Rezoning Transportation Analysis

Petition Number: 2024-024

Date	Description
3-27-24	First Review (TM)
04-24-24	Second Review (TM)

RZ-1.0

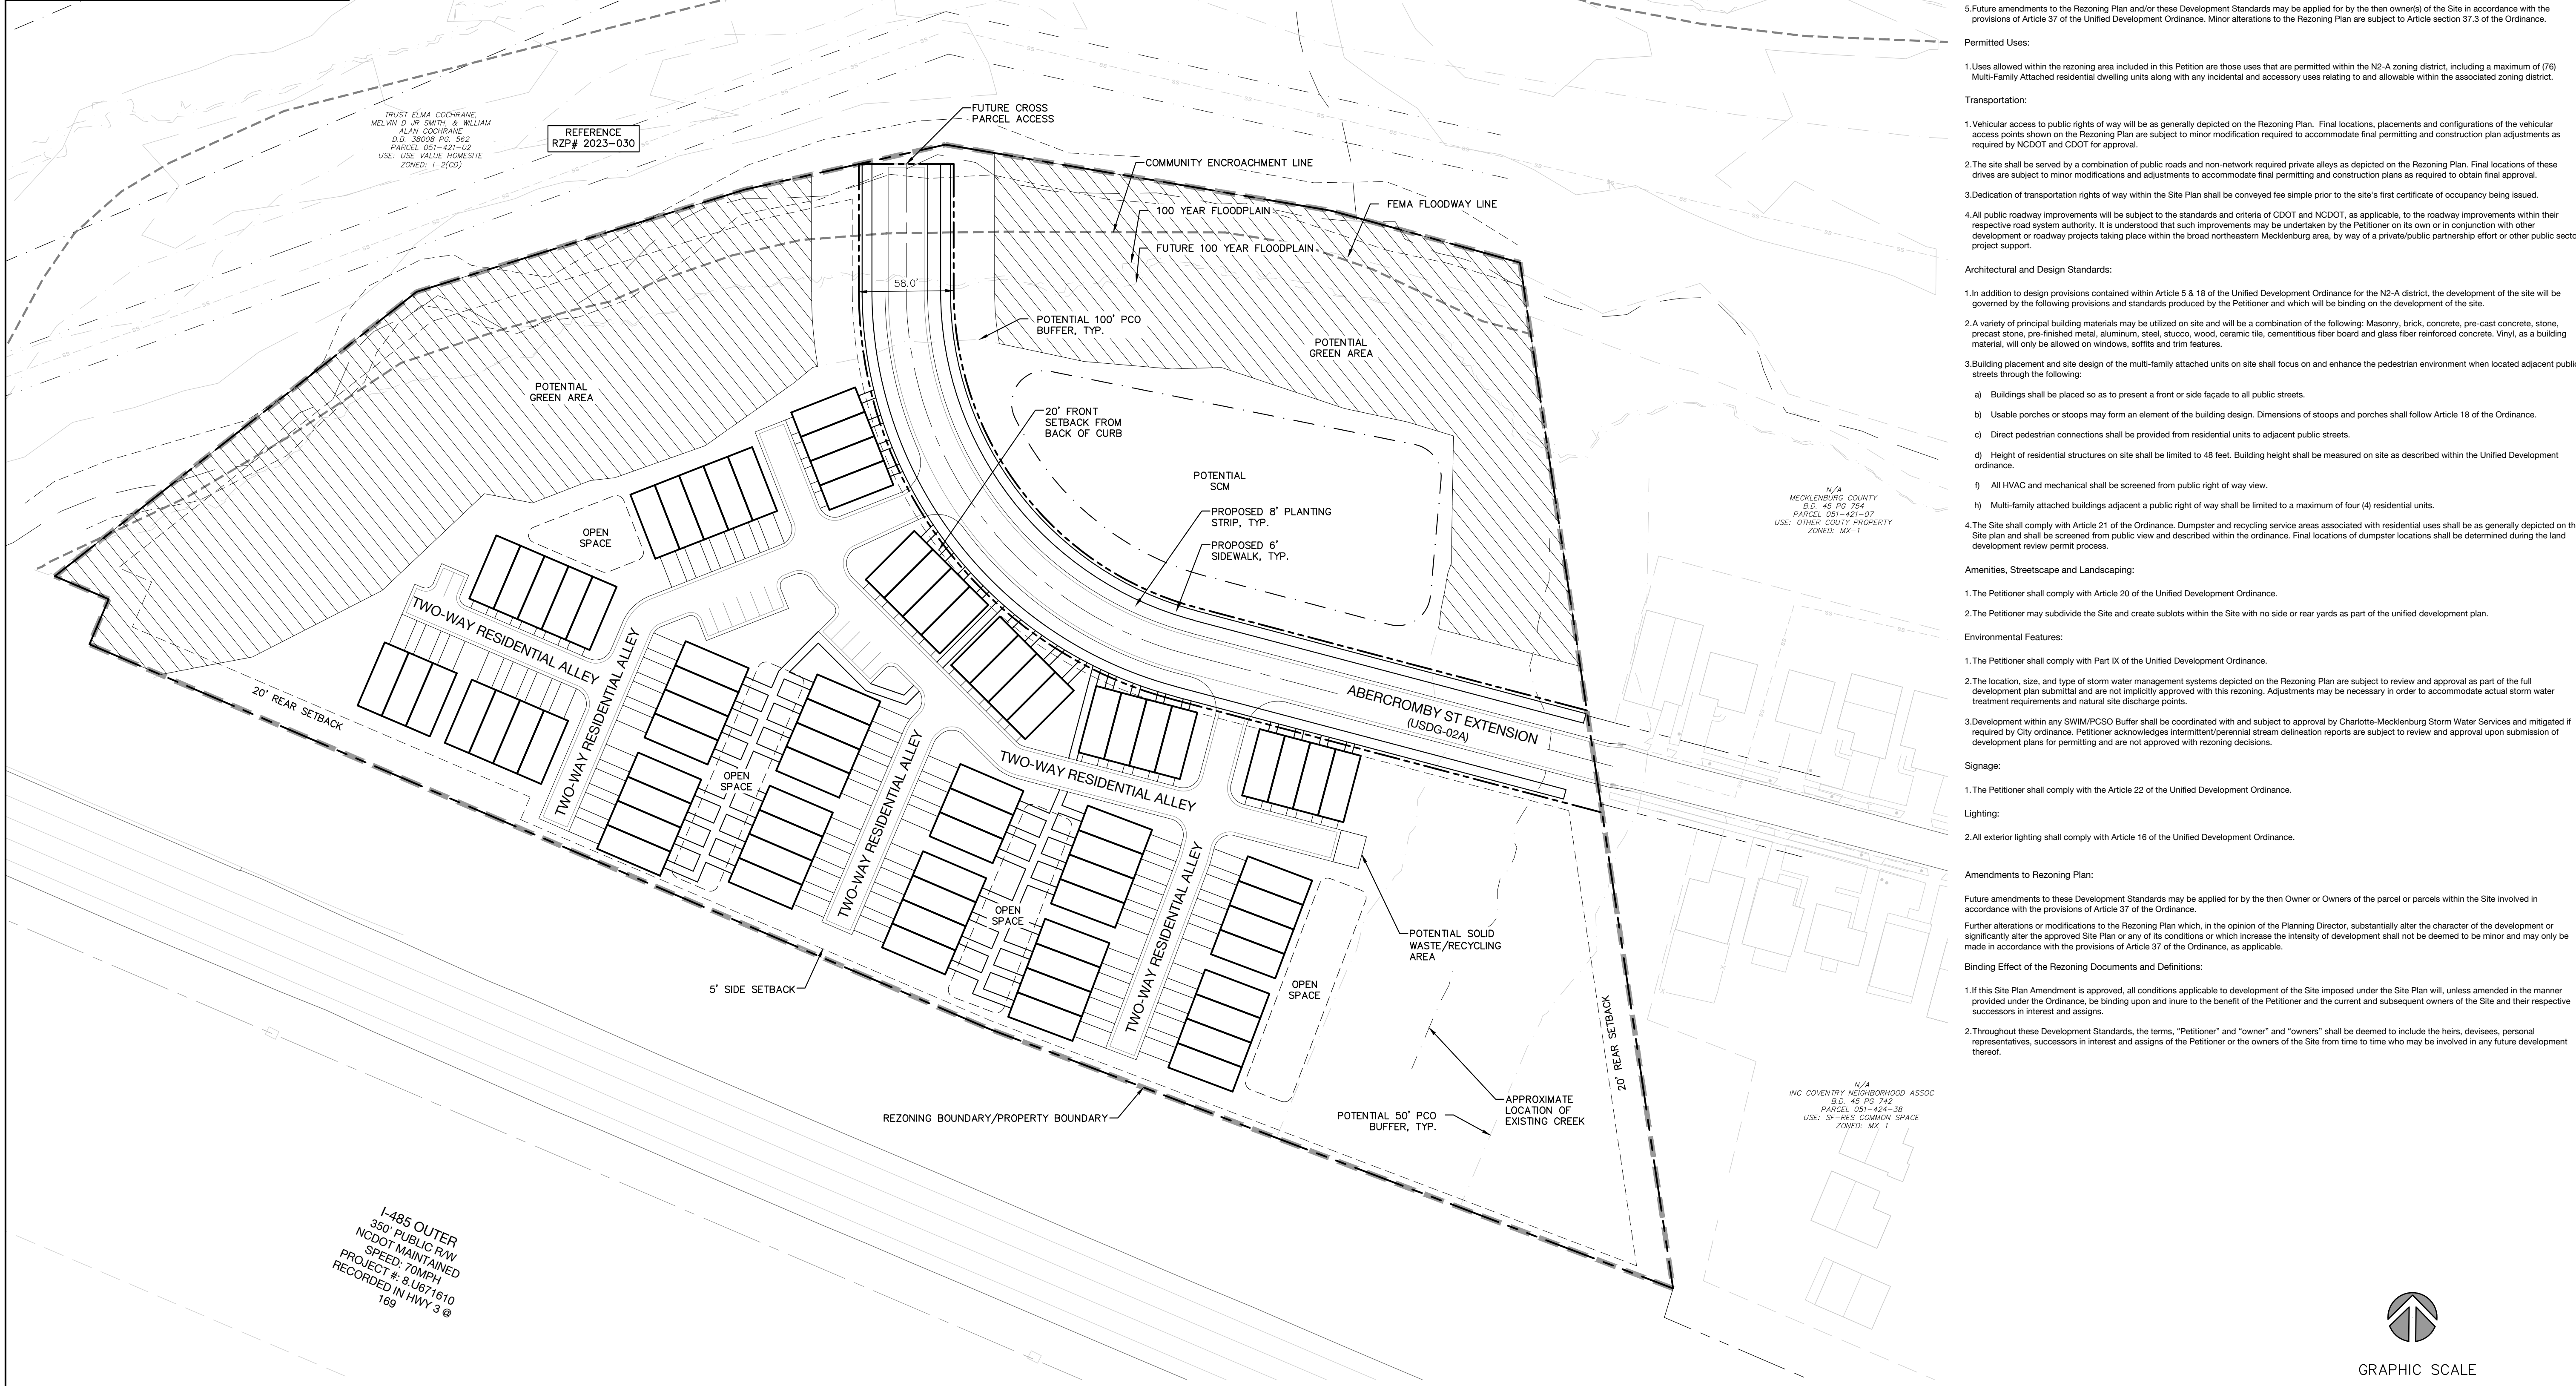
- a. ~~Abercromby Street: Location of future back of curb and gutter is to be located at 15 feet from roadway centerline per CLDSM U-02B.~~

~~Label and dimension the curb and gutter from the centerline for each road on the site plan.~~

3. ~~Revise site plan and conditional note(s) to commit to dedicate 29 feet of right of way from the road centerline. The site plan shall label and dimension the right of way from the road centerline.~~

- ~~4. Revise site plan and conditional notes to commit to connecting Abercromby Street stub to adjacent development in coordination with CDOT and NCDOT.~~
- 5. Outstanding Issue from 3-27-24:** N-2 requires that the roadway be constructed to a residential wide roadway cross section (CLDSM U-03) Per UDO. To remain consistent, CDOT request that this roadway remains as proposed, a residential medium (CLDSM U-02) matching the cross section of approved rezoning 2023-030 and that additional onsite parking stalls are added to the southeastern portion of the site in lieu of providing the on street parking that is provided with a U-03 roadway cross section. Revise site plan and conditional notes to commit to installing parking stalls.

Clarifying comment 04-24-24: Roadway cross section is called out as USDG U-02. Please revise all reference to roadway standard cross section to be CLDSM U-02.

- ~~8. Revise site plan and conditional note(s) to construct 8-foot planting strips and 8-foot sidewalks Road and Abercromby Street extension. The site plan shall label and dimension both items from the back of curb and gutter or edge of pavement. Add conditional note The entire facility must be outside of the right of way and within a public access easement. Add conditional note committing to construction and maintenance of the 8-foot sidewalks/multi-use paths on Abercromby Street extension.~~
